DOC21/497894-16

**Response to Submissions  
Tomago Resource Recovery Facility and Truck Depot –  
21D and 21F School Drive Tomago  
SSD-10447**

## ATTACHMENT 1 – ADDITIONAL INFORMATION REQUIRED

Figure 4 General Layout of Building 2 [Source: REMONDIS Australia Pty Ltd]

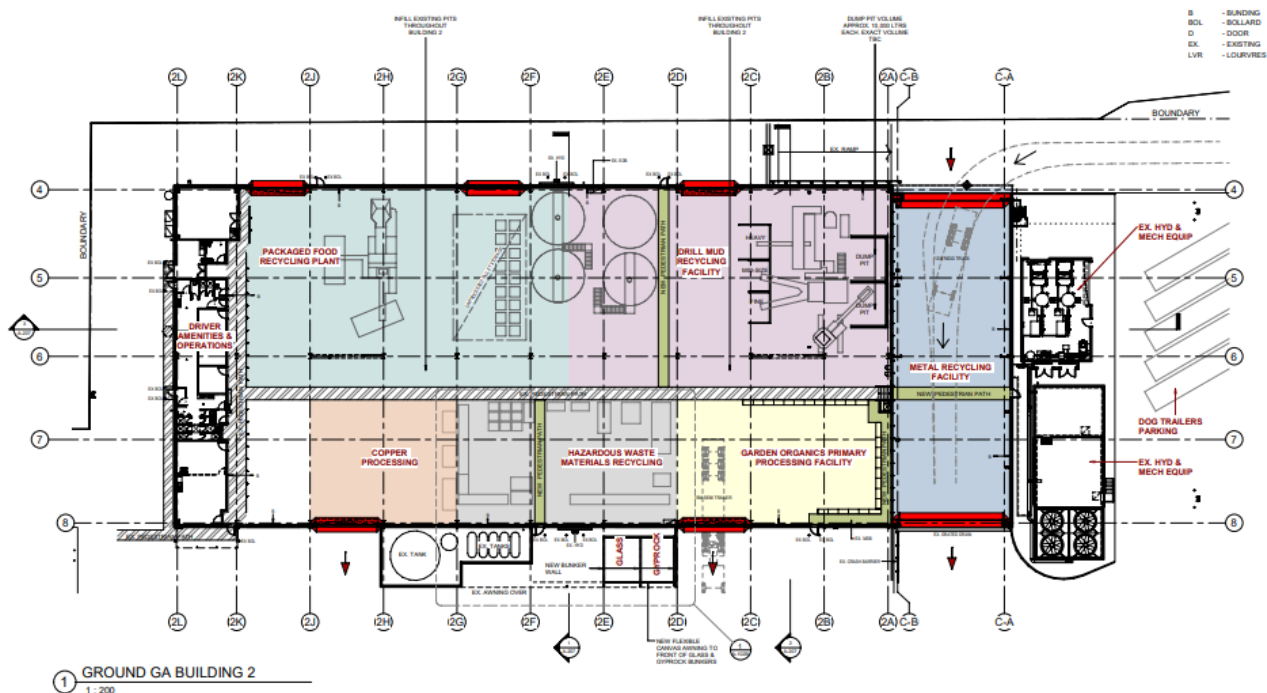
The EIS refers to Figure 3.4 (Appendix E) to provide an overview for the storage arrangements of waste materials in the Hazardous Waste Recycling Facility (HWRF), however details of the actual storage are not provided in this figure, and thus it is not possible to confirm the proposed plant, such as tanks, required for the HWRF.

In addition, the EIS states (Appendix E, Section 4.3.3) drill mud on receipt will be pumped into a bunded 50,000 litre drill mud holding tank, while post treatment dewatering drill mud liquid will be pumped to (presumably) another a 50,000 litre holding tank for testing prior to offsite transport.

However, only one 50,000 litre tank for drill mud liquid is included in Section 4.4 of Appendix E of the EIS.

- the processes and plant that will be used to manage the decanting, conveying and transfer of liquid waste between tanks, containers, and other storage;
- the controls that will be implemented to address leaks, spills, or discharge of liquid waste; and
- the controls that will be implemented to address odour emissions, including from the handling and storage of liquid waste such as waste oil, oily water, residual solvents thinners and paints, and drill mud, noting each will or may contain hydrocarbons.

2. *Provide detailed information to clarify drill mud and liquid waste storage and infrastructure requirements; and*
3. *Clearly identify and justify controls to be implemented to mitigate risks associated with waste activities, and in particular liquid waste handling and storage.*
